M54 to M6 Link Road

TR010054

**8.30 Letter of No Impediment for Great
Crested Newt**

DRAFT MITIGATION LICENCE APPLICATION STATUS: SUBSEQUENT DRAFT APPLICATION
LEGISLATION: THE CONSERVATION OF HABITATS AND SPECIES REGULATIONS 2010 (as amended)
NSIP: M54 to M6 Link Road
SPECIES: Great Crested Newts

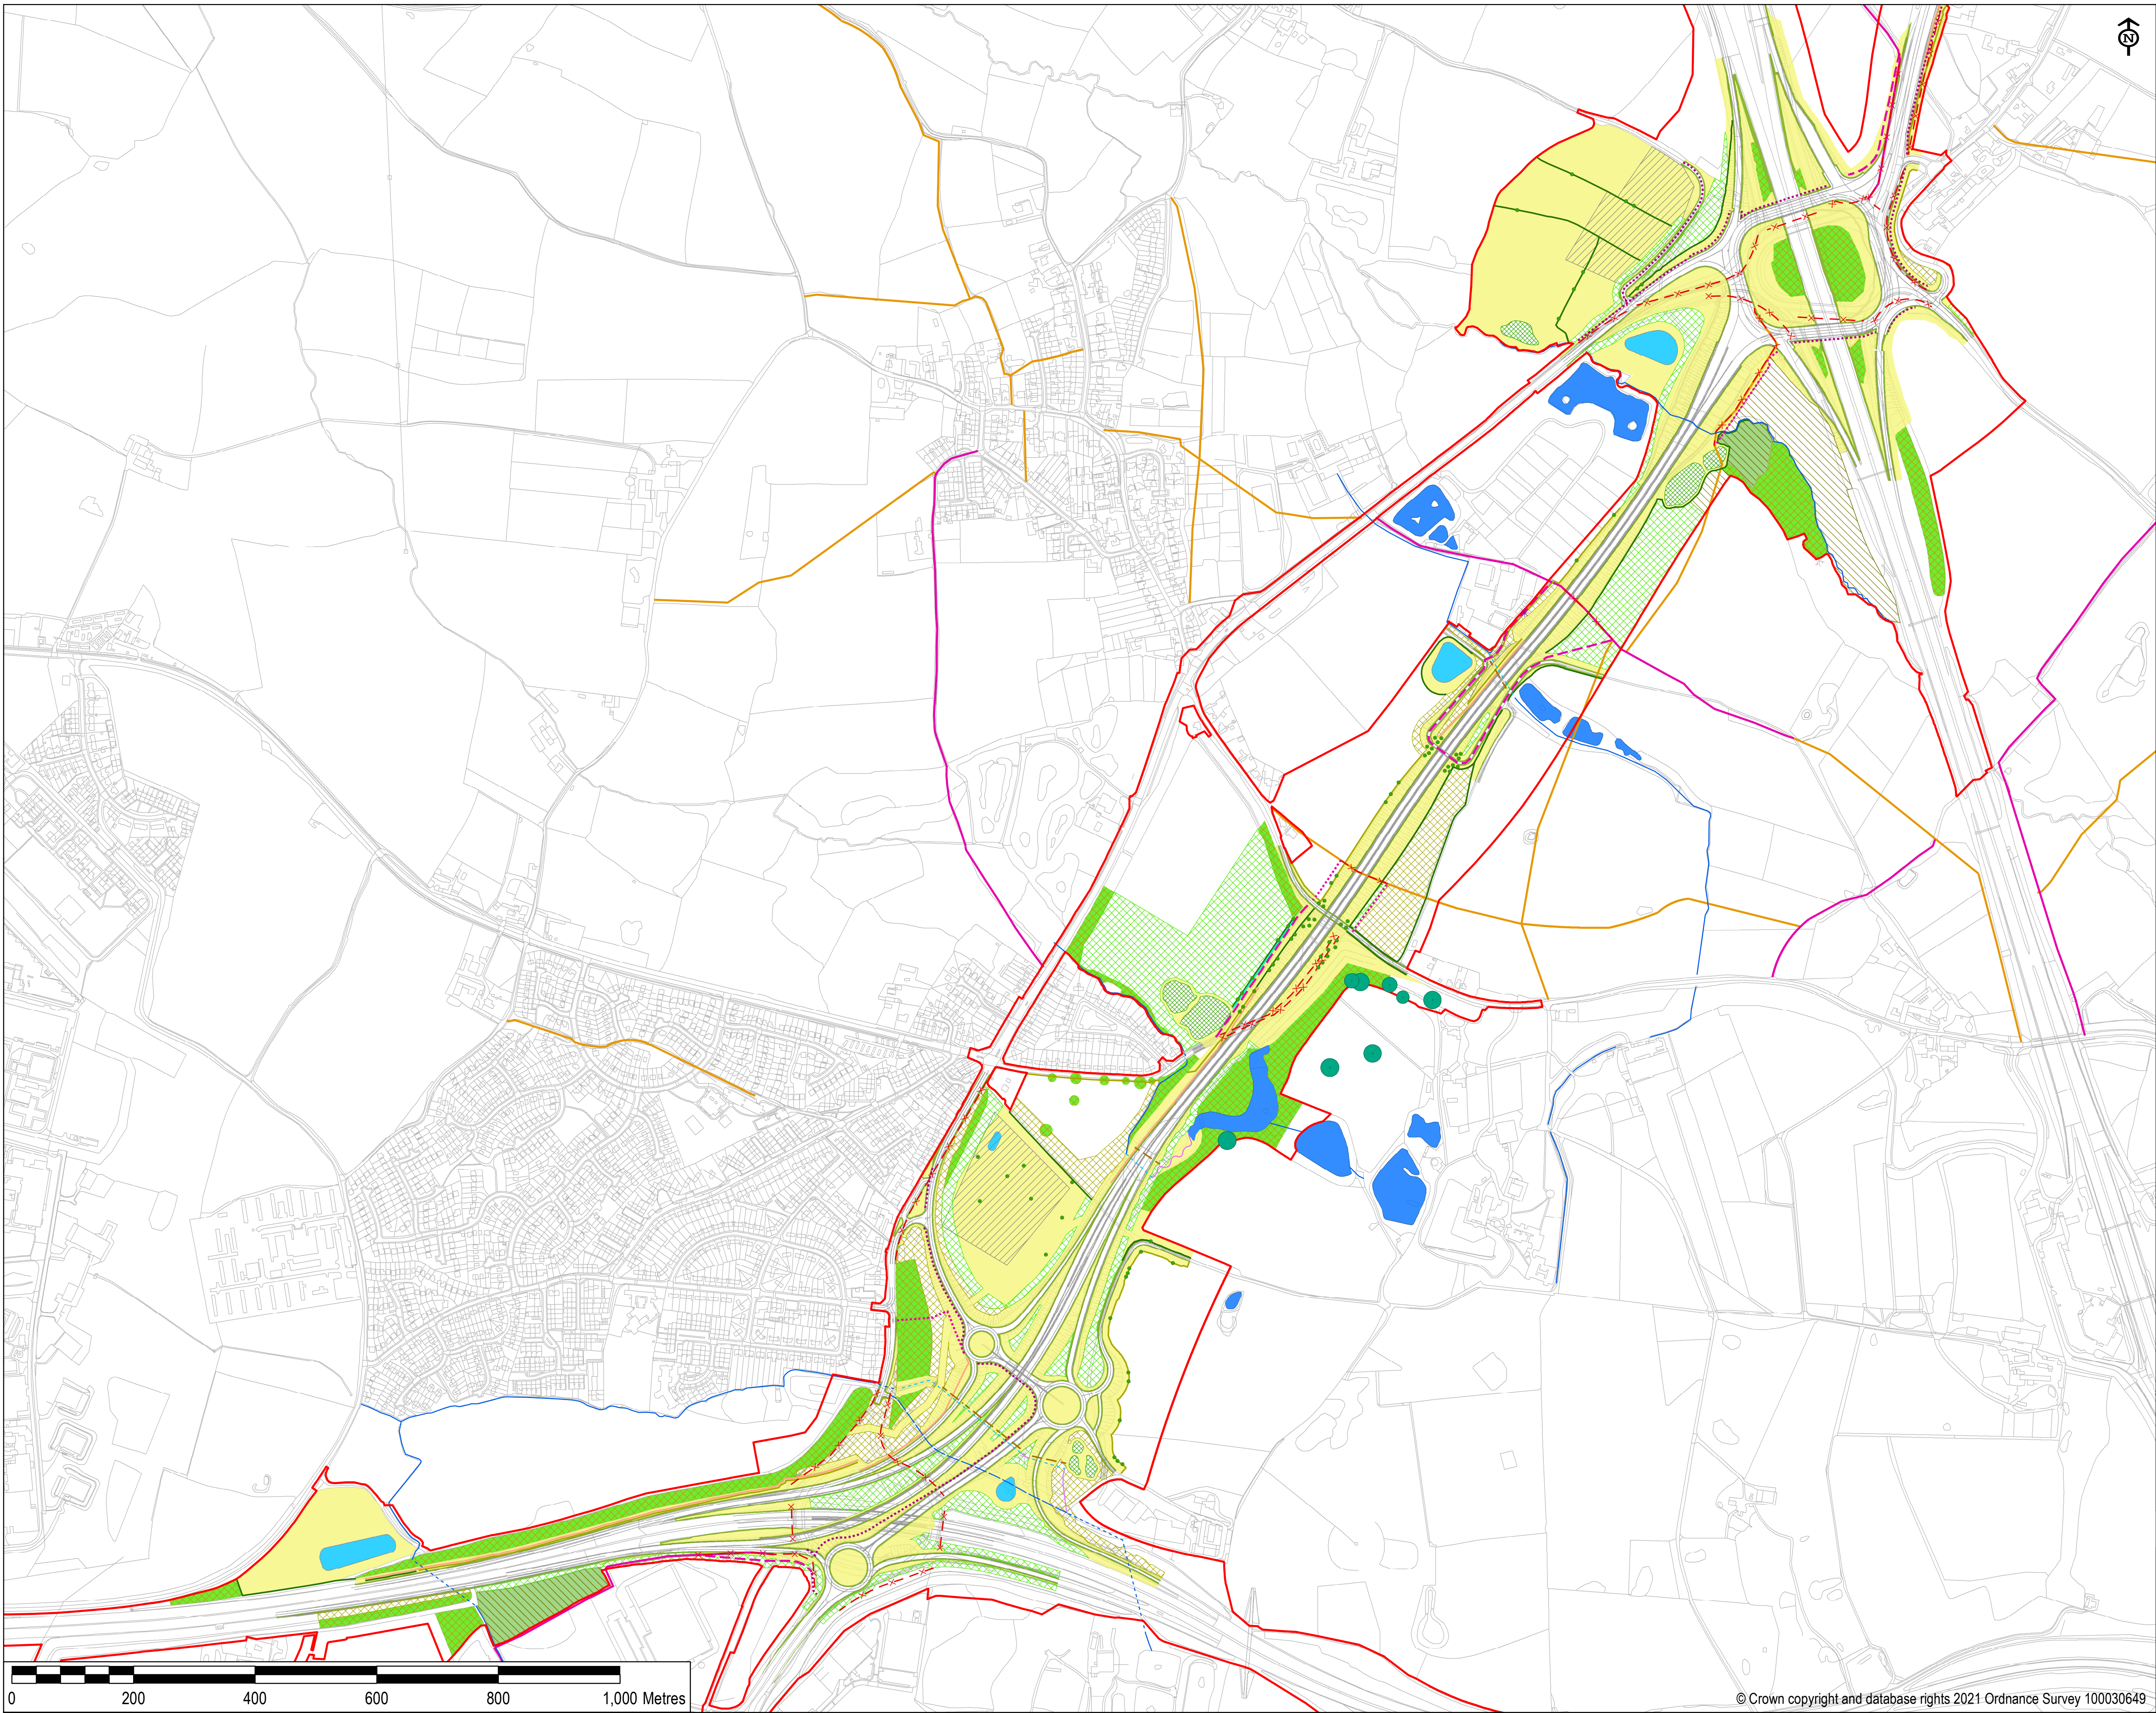
The present compensation strategy needs to be reconsidered. Much of the proposed compensation or enhancements are proposed in locations that do not support GCN or a wider metapopulation. The compensation should be relocated to a more appropriate location or stronger connectivity measures should be put in place to help GCN colonise these areas.

For instance, the terrestrial habitat around new GCN waterbodies EP06, EP07 and EP08 lies outside of both metapopulation 6a and metapopulation 4. However, it may be possible to provide stepping-stone waterbodies to help GCN naturally colonise this area.

In addition, EP04 and EP05 will become isolated from all known metapopulations of GCN. Given the road network dispersal barriers, it is unlikely that they will become naturally colonised. The location of these waterbodies will need to be reconsidered to ensure they can provide the intended compensation and be accessible to a known GCN population.

There are two ponds to the west of the Scheme here, EP04 and EP05. These have been included in the mitigation design to replace habitat lost within Lower Pool Site of Biological Importance and Local Wildlife Site (LWS). We are also planting an area of woodland and grassland to the east of the Scheme as part of the compensation for the LWS. These ponds should not have been included as part of the Method Statement; these ponds are not required as compensation for impacts on GCN.

█ – This is understood. These ponds should be separated out in the full application, with the ponds shown as part of the wider mitigation strategy but not as part of the compensation for GCN.

█ – Yes, these ponds are required to replace a pond lost during the construction of M54 Junction 1. GCN are absent from this existing pond. The ponds here (EP06, 07 and 08) are included to compensate for the loss of
